**Your Ref:** OWPC11027  
**Our Ref:** AL/107/16/RES 29-09-2016  
**Please ask for:**  
Hilary Kernohan

Application for Reserved Matters application following Outline Planning Permission AL/39/13 for the demolition of Oakdene and all other structures within the site and the erection of 79 dwellings, public open space, children's play areas, landscaping, drainage measures, sub-station, pumping station and all other associated works.

Land West of Westergate Street & East of Hook Lane Westergate

Thank you for your internet representation made on 28th October 2016 which has been recorded as **'an objection'** with the comments as follows:

Drawing Title:-
**STREET LIGHTING
LAYOUT**

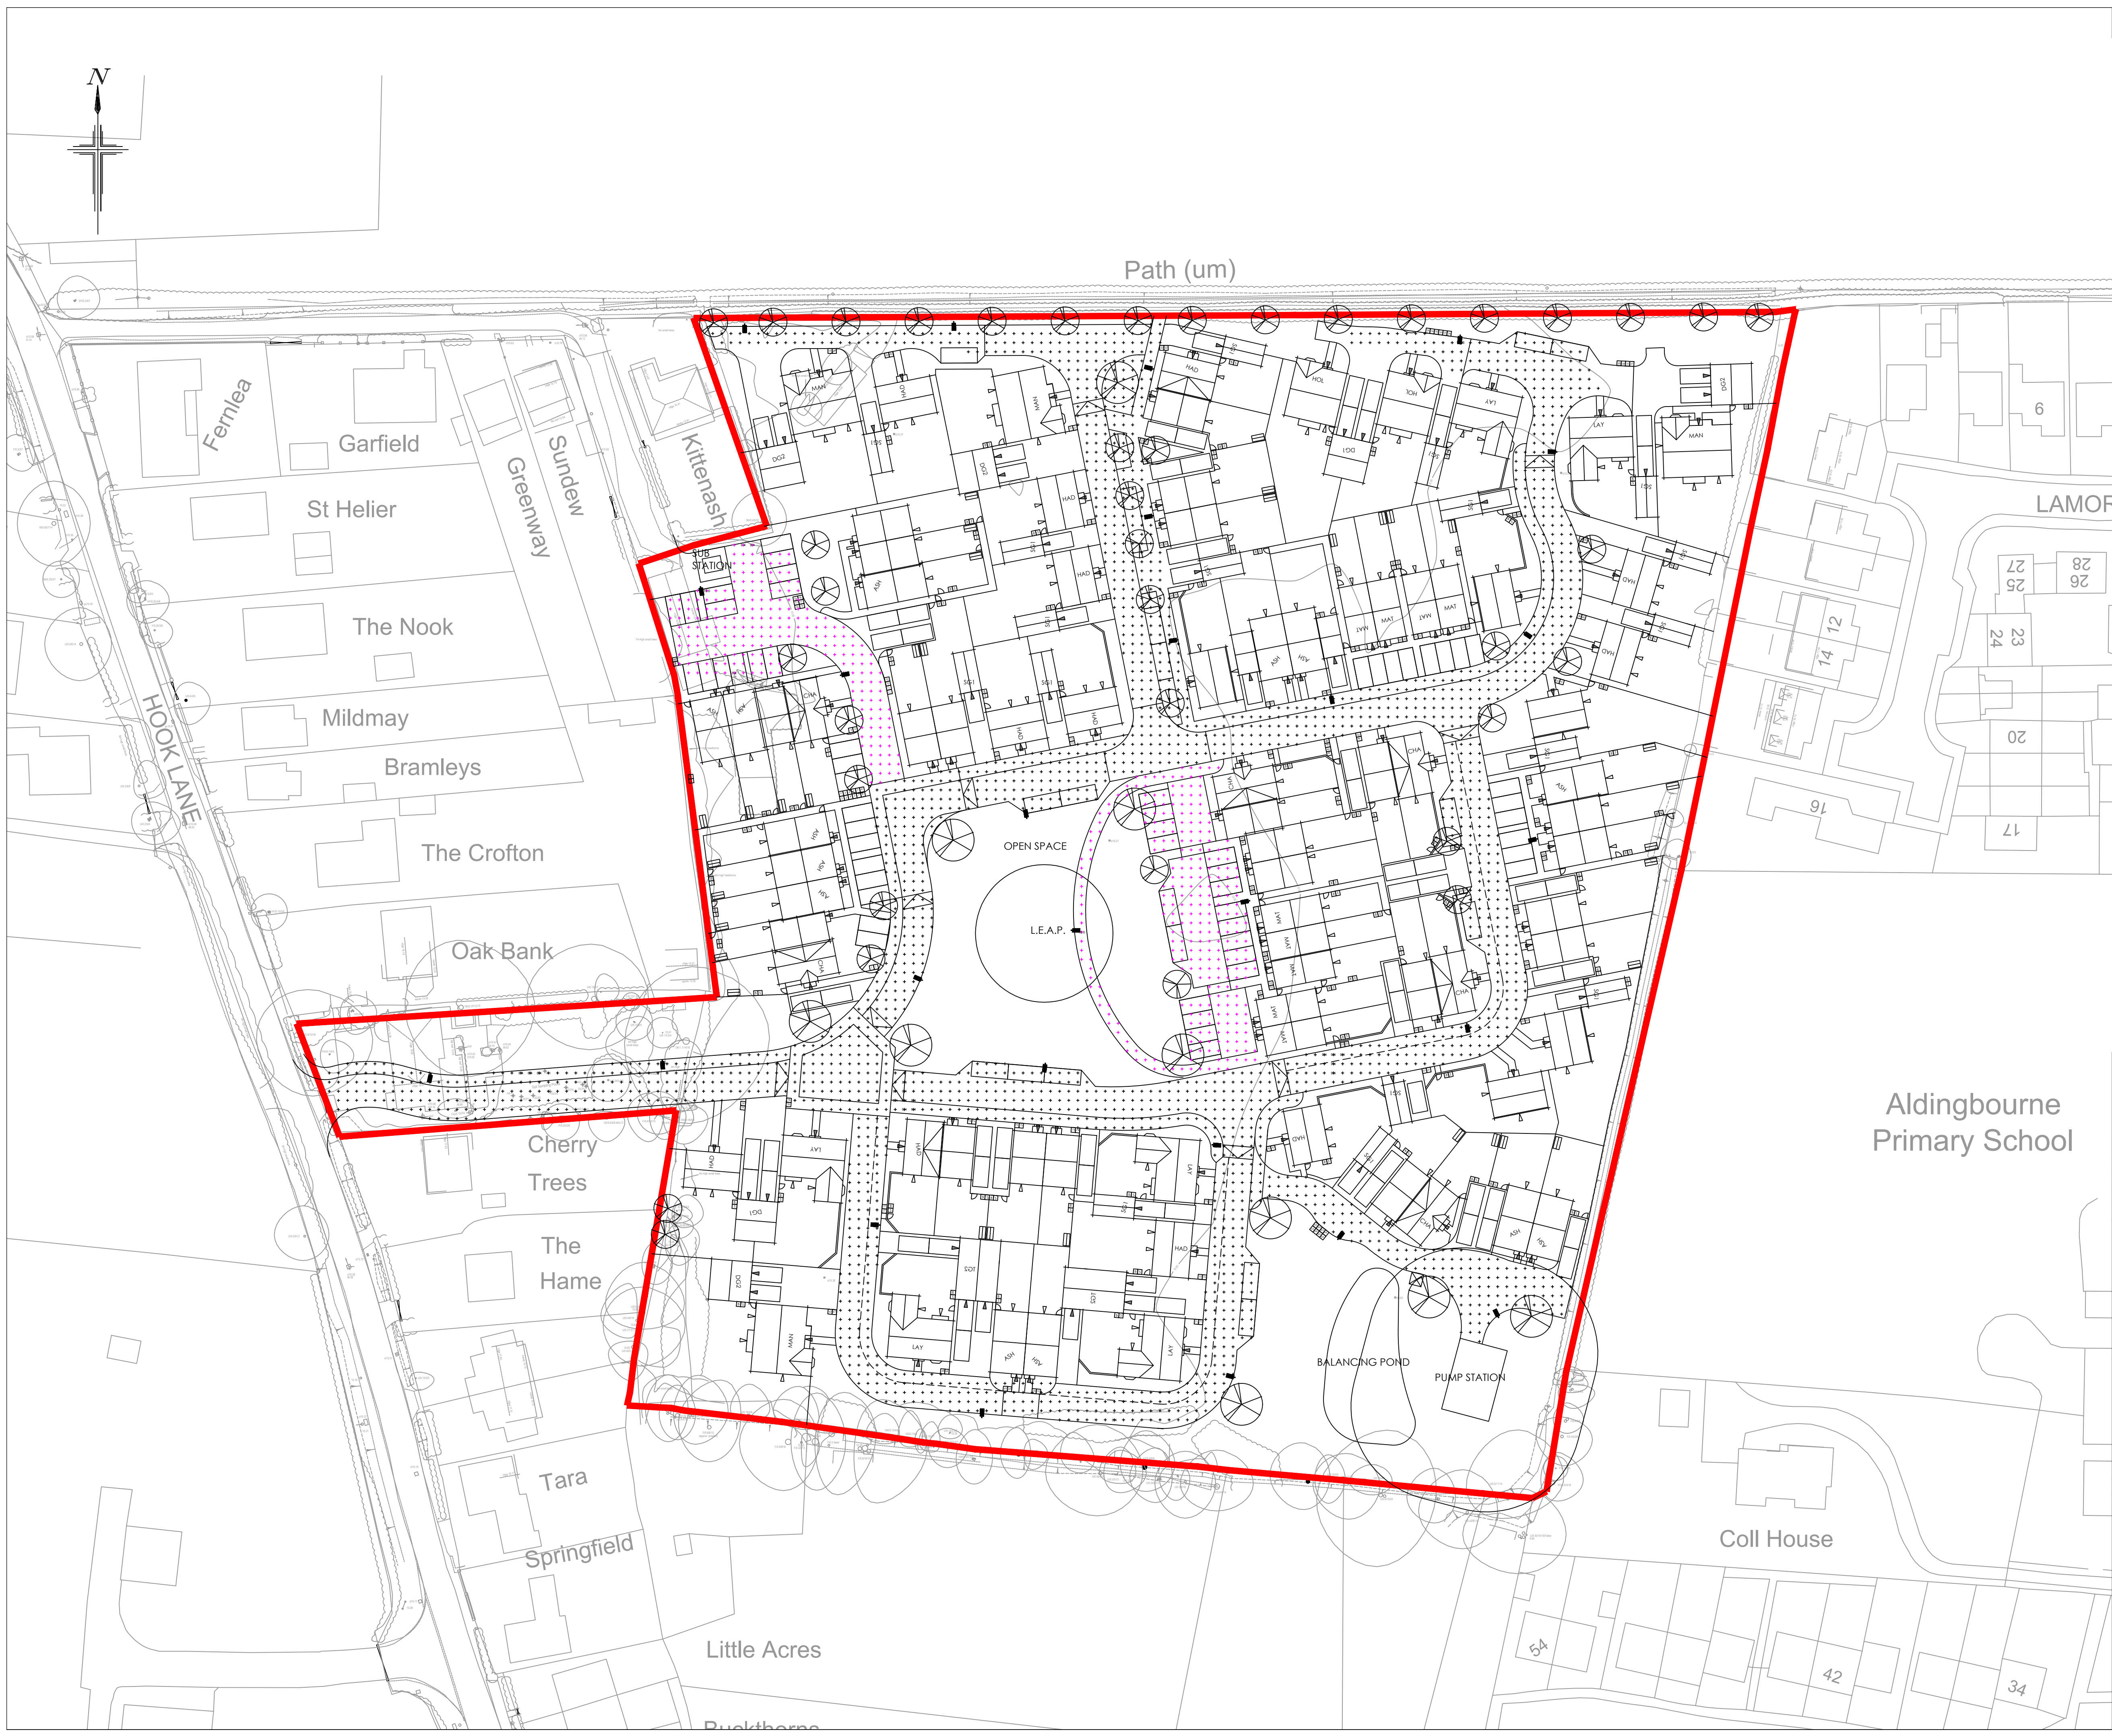
- 2. Multi parking spaces are directly to the rear of Kittenash and must be moved.*
- 3, There is a lamppost in this parking area which cause light pollution into Kittenash.*

- 7. A light at the northwest edge of the development will cause light pollution into bedroom, lounge and conservatory.*
- 8. Our right to light will be curtailed by the planting of 4 trees in the northwest of the development. This is on the edge of Kittenash, next to mature trees in Kittenash(not shown on ACD Enviromental plan). These are in a 45degree splay of our window.*

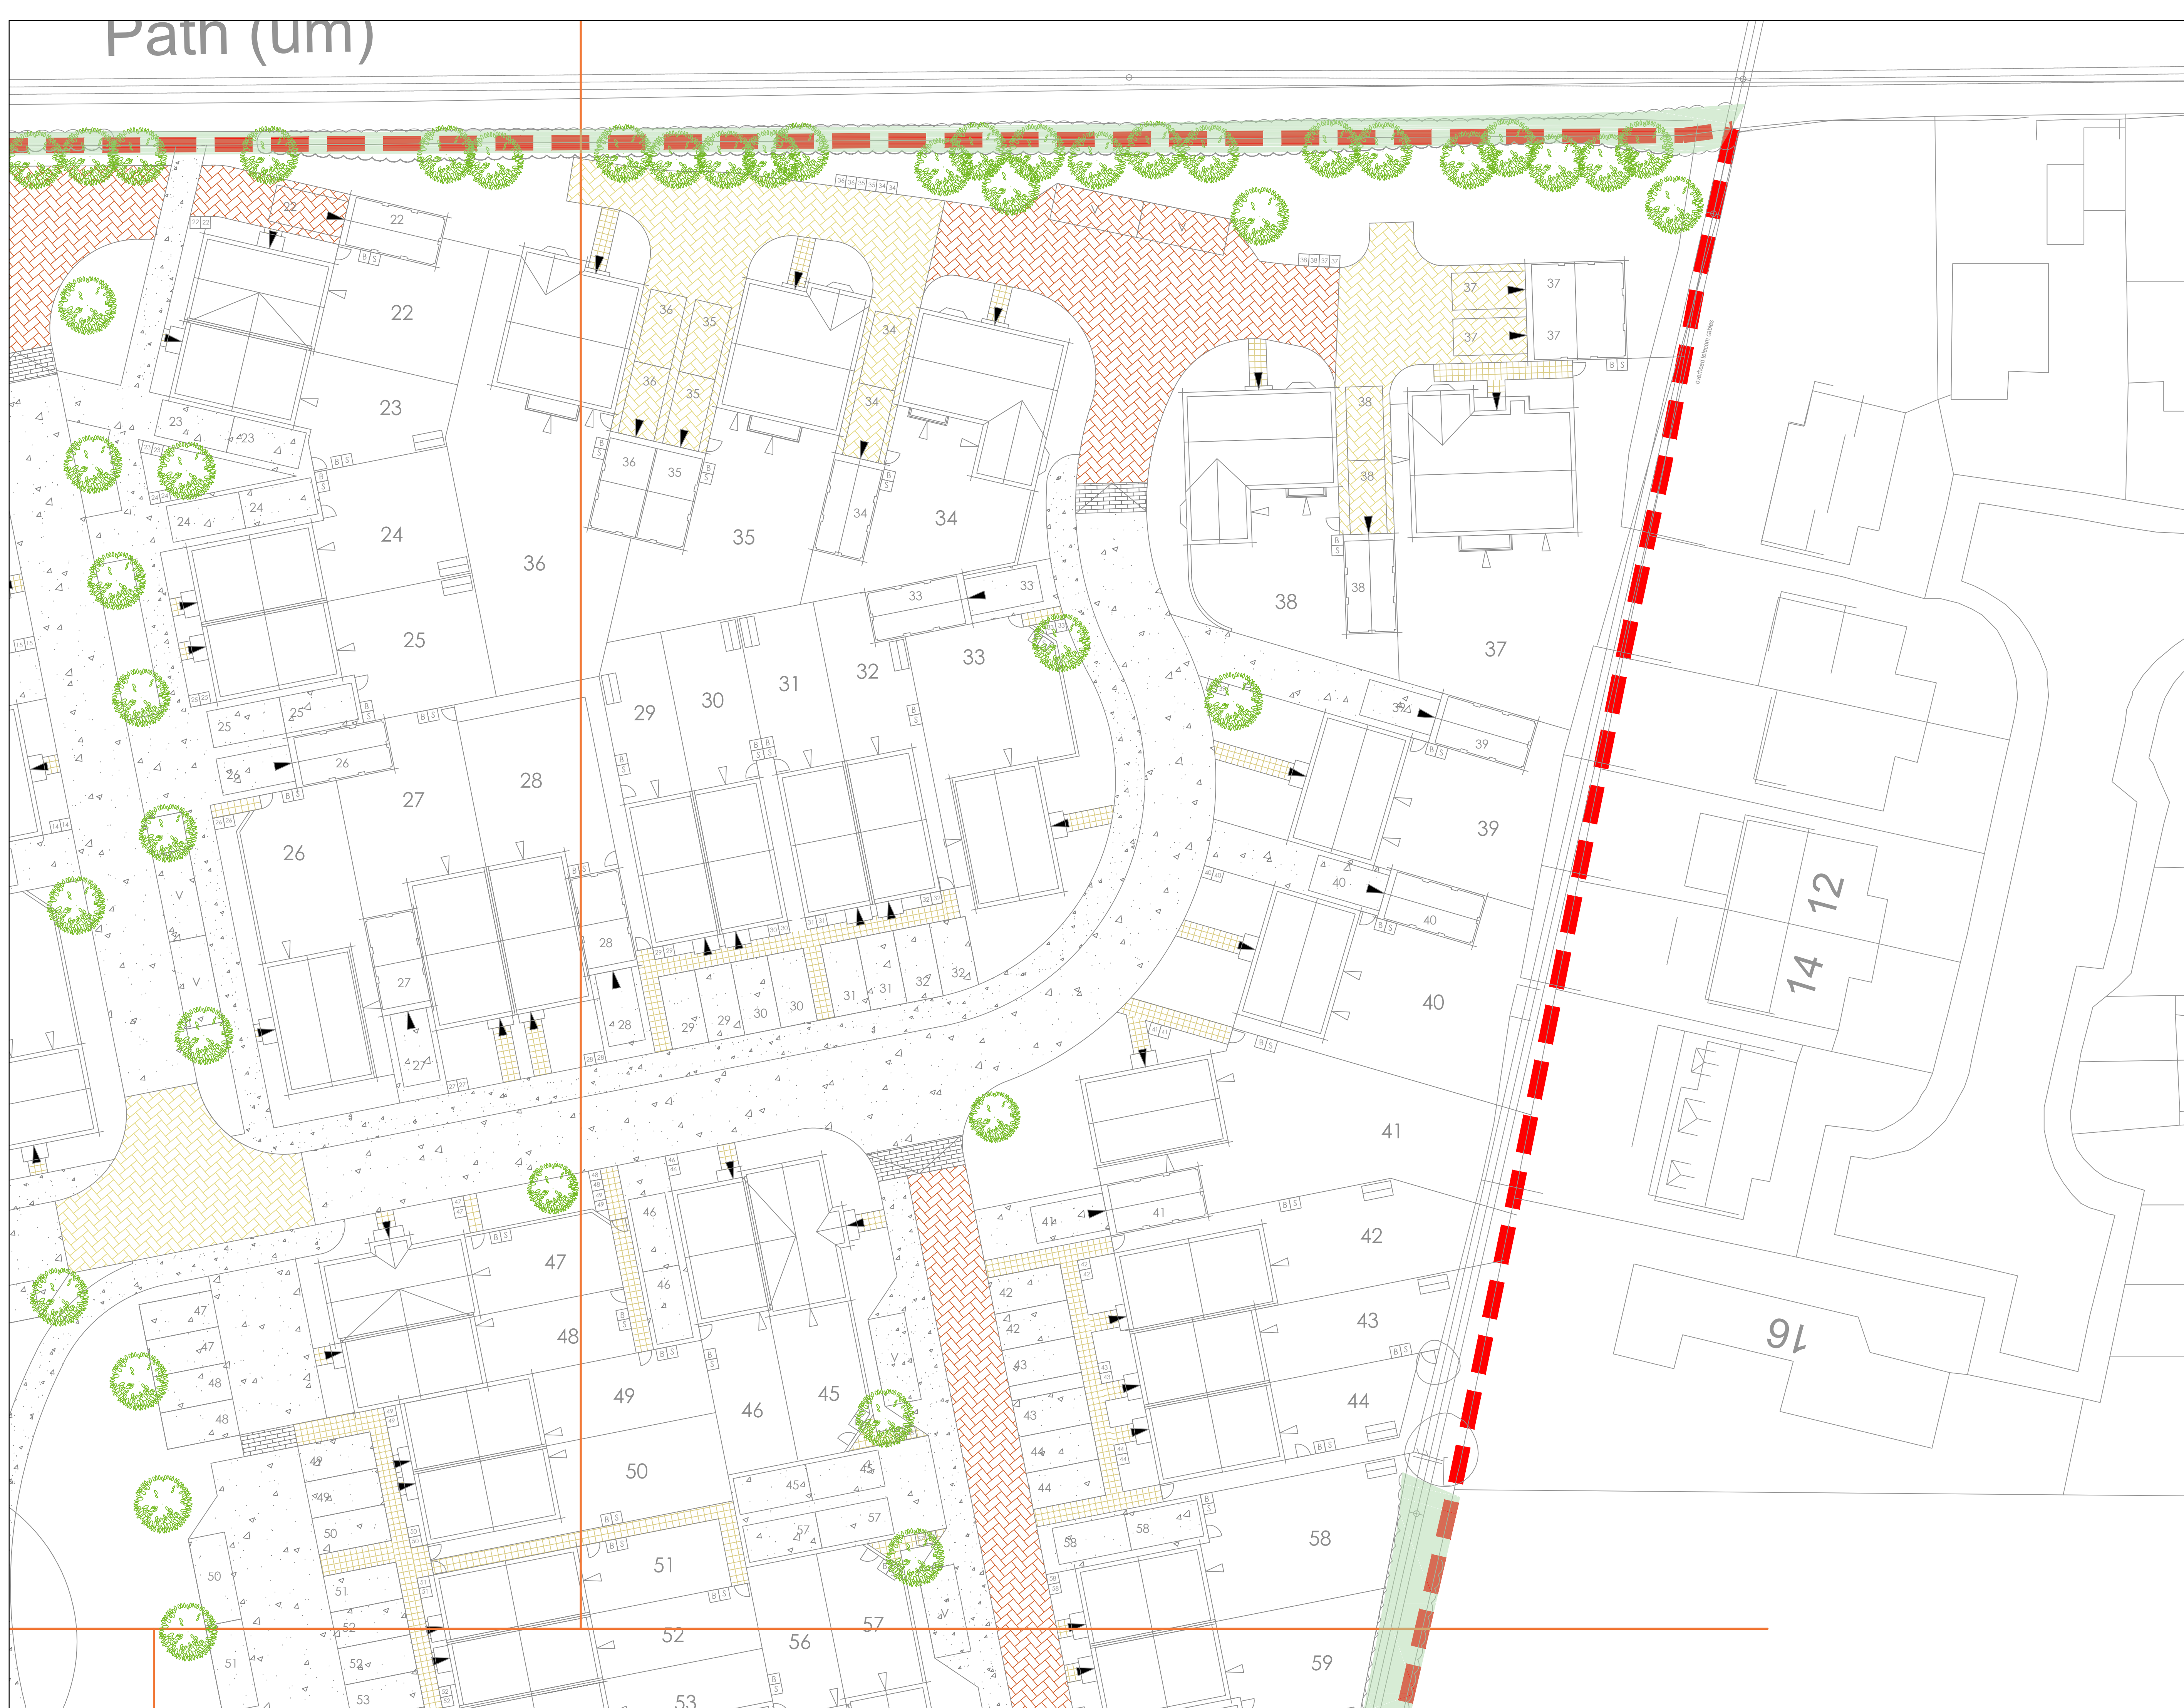
- 4. I will suffer antisocial behavior because of the car parking site, and possible criminal behaviour.*
- 5. Accoustic fencing must be installed, not a hedge to the south of Kittenash.*

- 6. Fencing must be installed to the east and south of Kittenash, as there is already a hedge at the boundary and further hedging will mean many problems maintaining both hedges.*
